DELEGATED DECISION TO DETERMINE PLANNING APPLICATIONS

Reference No:	2023/62/93233/W
Site Address:	Far Brow, Huddersfield Road, New Mill, Holmfirth, HD9 7JU
Description:	Erection of single storey front extensions and alterations
Recommending Officer:	Molly Storer

Officer Report

Drawing Title. **PLANNING FLOOR LAYOUT PLANS AS PROPOSED**

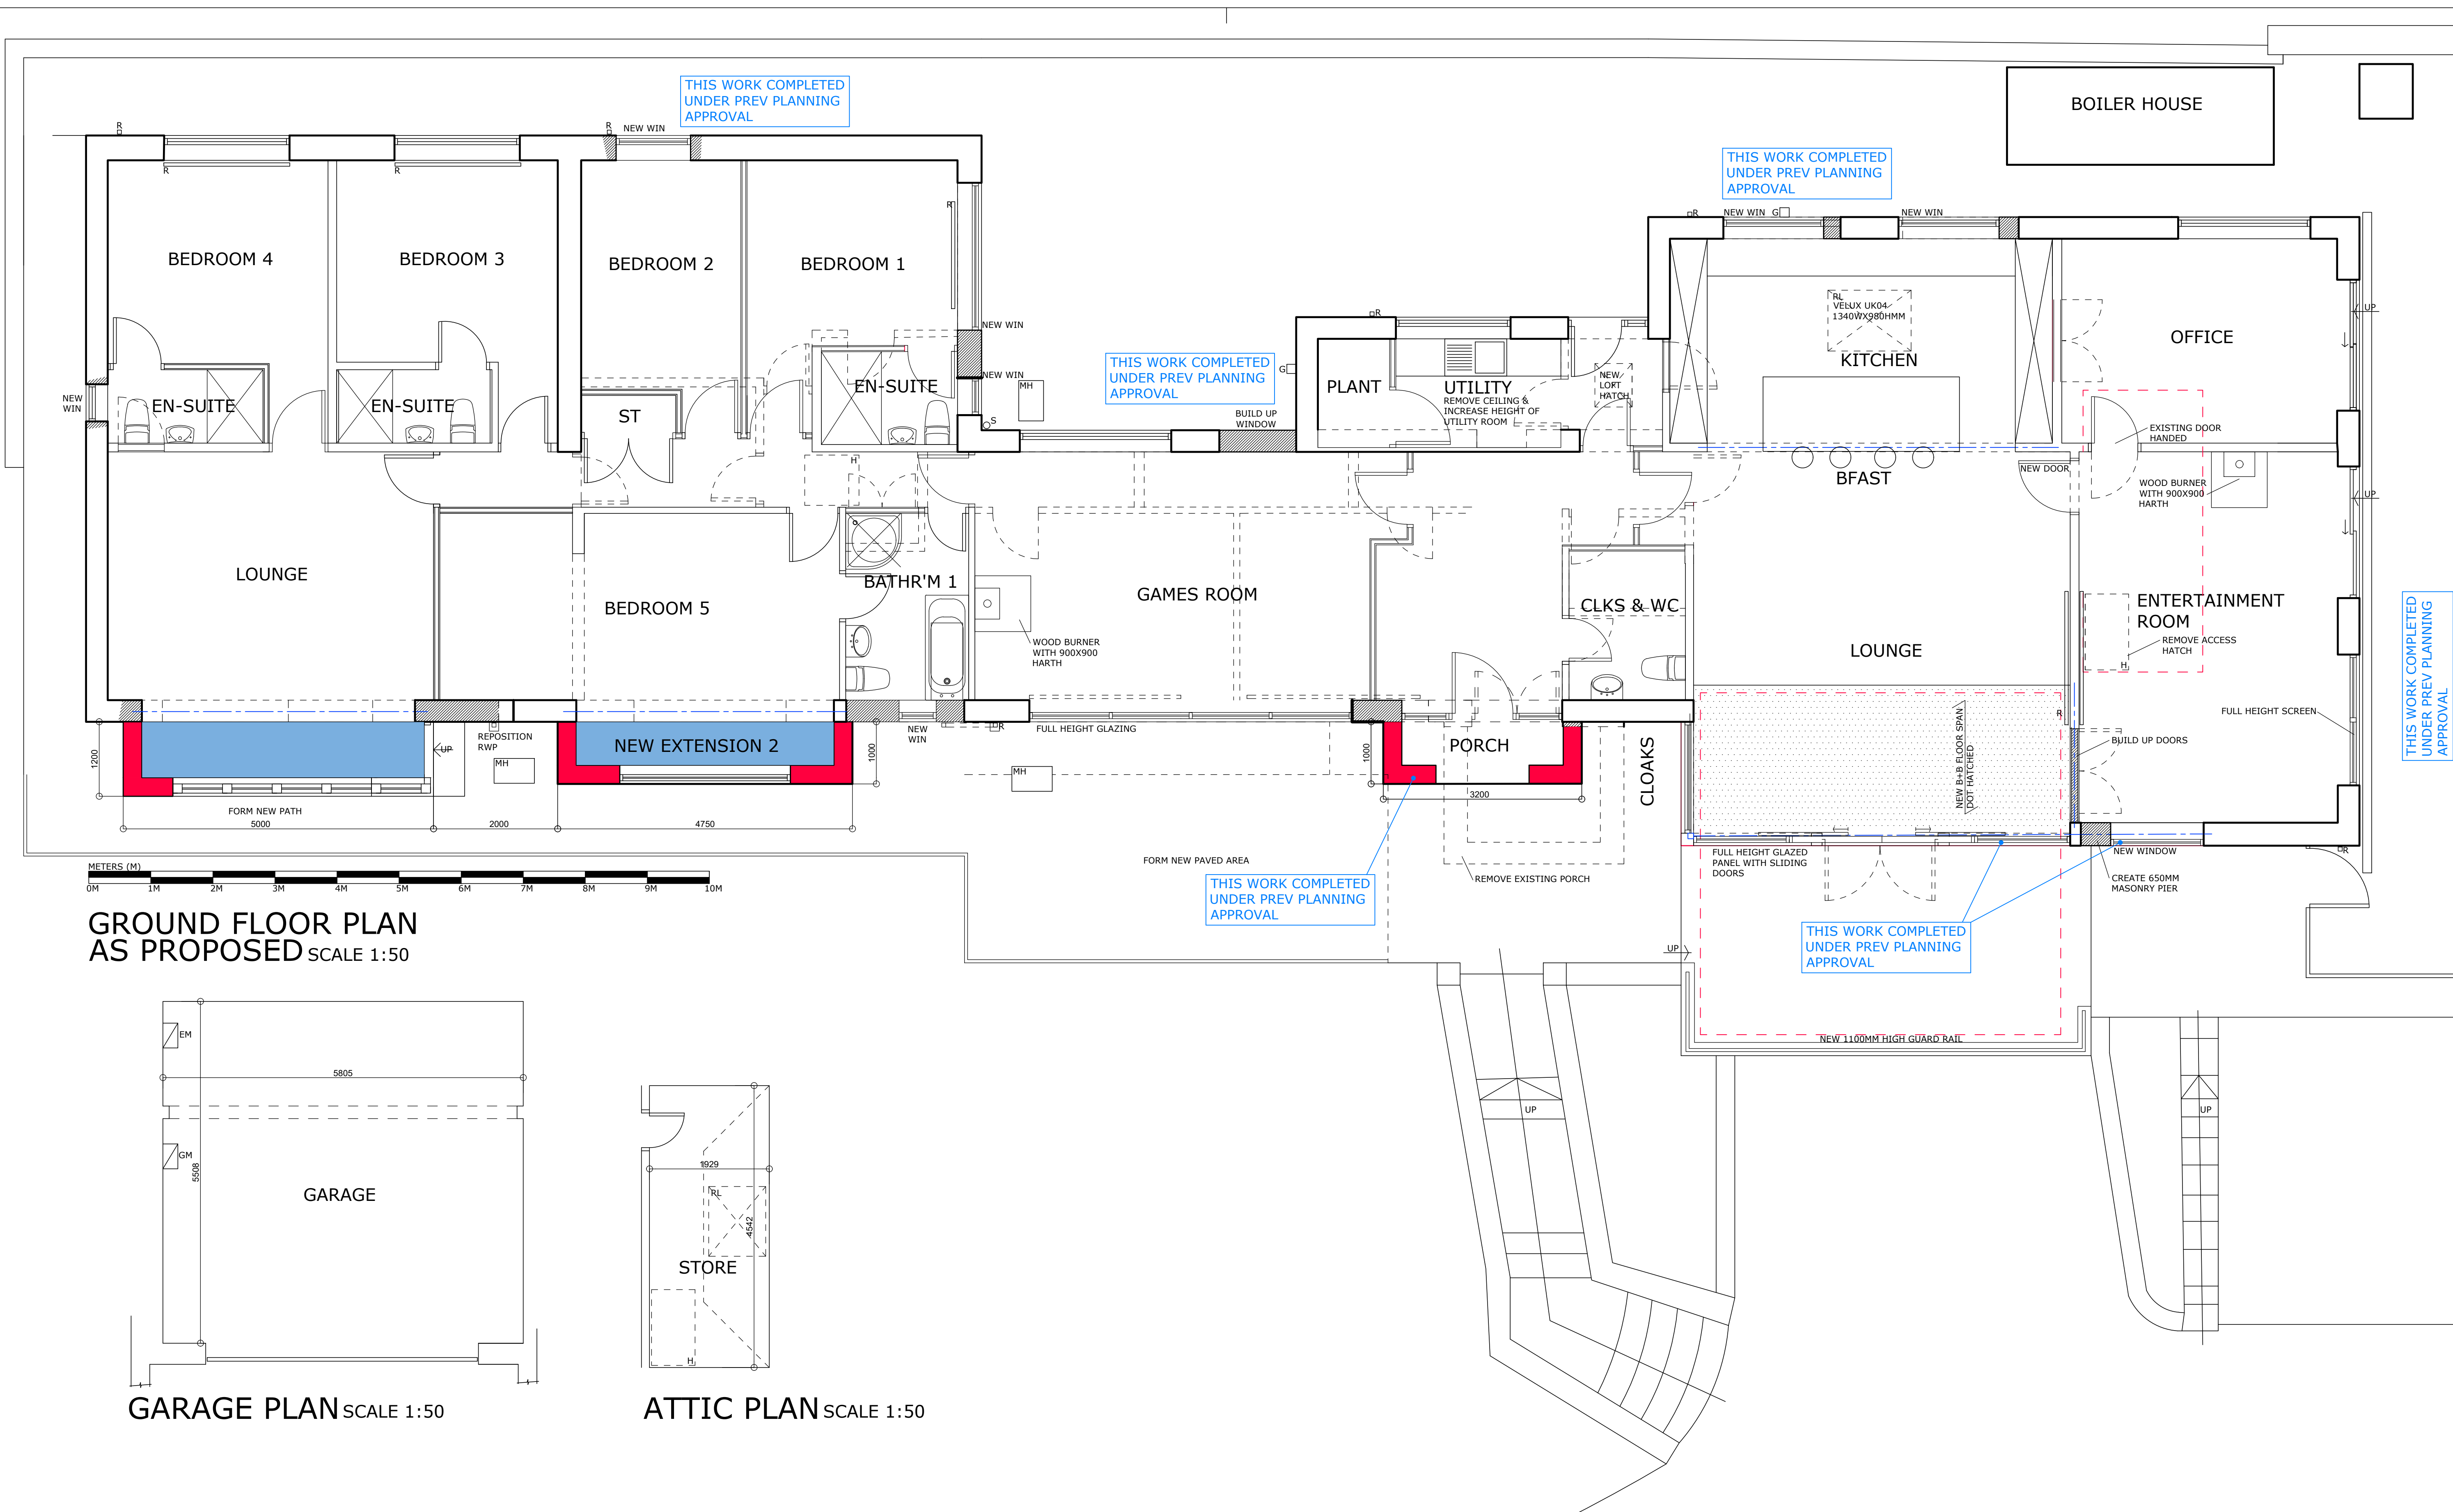
The application seeks planning permission for the demolition of existing porch, erection of porch, two single storey front extensions and exterior alterations, principally windows.

Principle 7 of the Kirklees House Extensions and Alterations SPD highlights that new development should ensure that an appropriately sized and useable area of private outdoor space is retained. In this instance the majority of the front garden/amenity space would be retained, with all of the existing garden/amenity space to the side and rear to be left as existing. The proposals are therefore considered to be in accordance with Principle 7.

Drawing Title. **PLANNING ELEVATIONS & SITE PLANS AS PROPOSED**

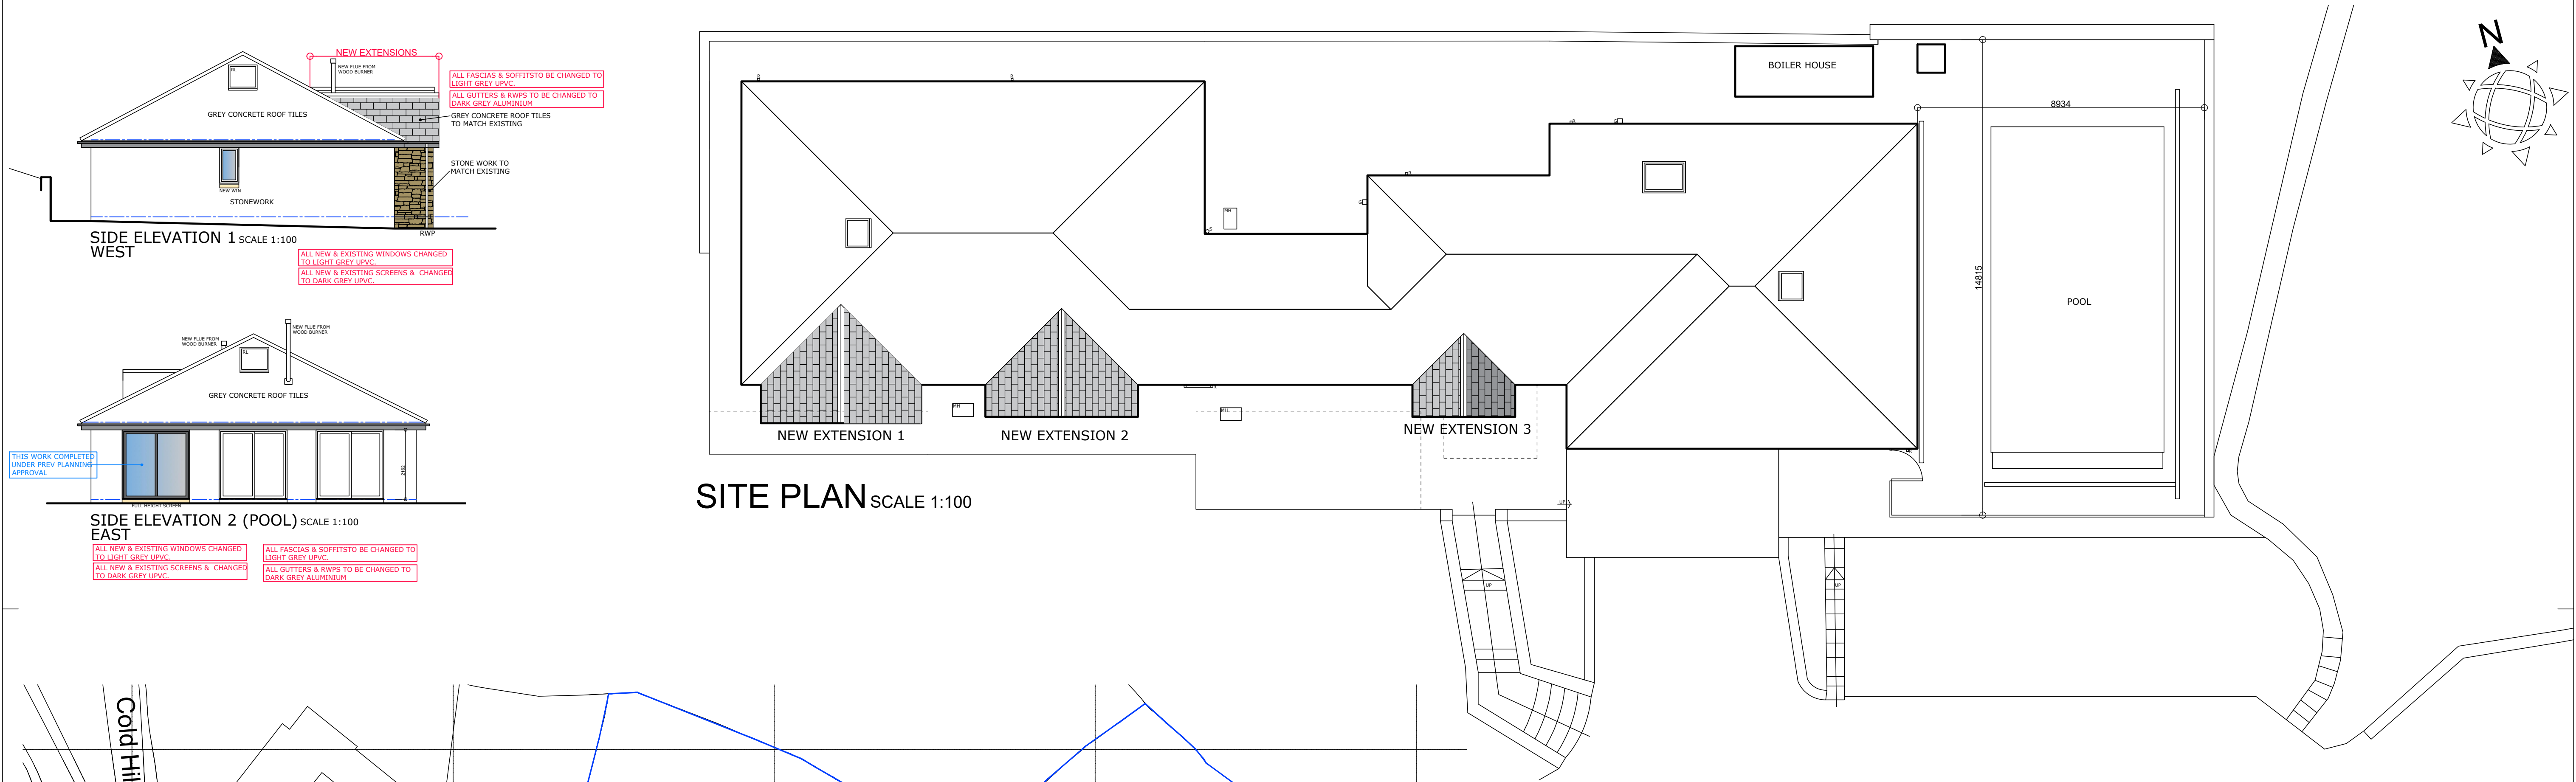
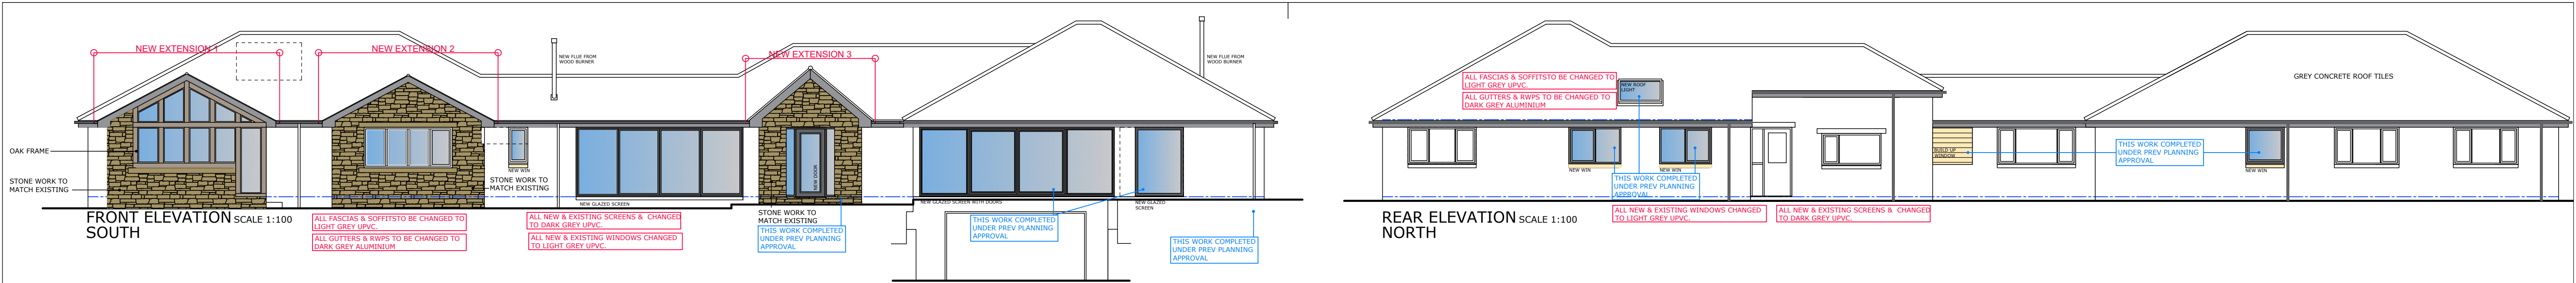
The proposed porch is to be located in a similar location to the existing porch and is to measure approximately 1m x 3.2m, with a ridge height of ~4.3m.

The first single storey front extension is to be located off the lounge and is to measure approximately 1.2m x 5m, with a ridge height of ~4m.

The second single storey front extension is to be located off bedroom 5 and is to measure approximately 1m x 4.75m and also have a ridge height of ~4m.

The new extensions are to be constructed from stonework to match the existing dwelling, not render finish as previously proposed. The extension to the lounge would include a partly oak frame and grey concrete roof tiles also to match existing are proposed throughout.

In this instance the proposed porch extension, bedroom extension and lounge extension would all be set well back from the road and would be somewhat hidden given its location up a private access road. However, it is acknowledged that the dwelling may be visible from further afield given the topography of the site. The proposed extensions are small in scale and size and are considered to be subservient to the original building, and to be designed so as not to significantly harm the character of the original house or area. The materials and design would adequately harmonise with the existing features of the dwelling. Finally, the extensions are not considered to unreasonably affect any adjacent neighbouring properties (as discussed in more detail in the below subsection).

In addition, the proposed exterior alterations relate to the installation of new windows, and paving. In addition, all new and existing windows will be replaced with light grey UPVC, all new and existing screens will be replaced with dark grey UPVC, all gutters will be replaced with dark grey aluminium and all fascias to be replaced with light grey UPVC.
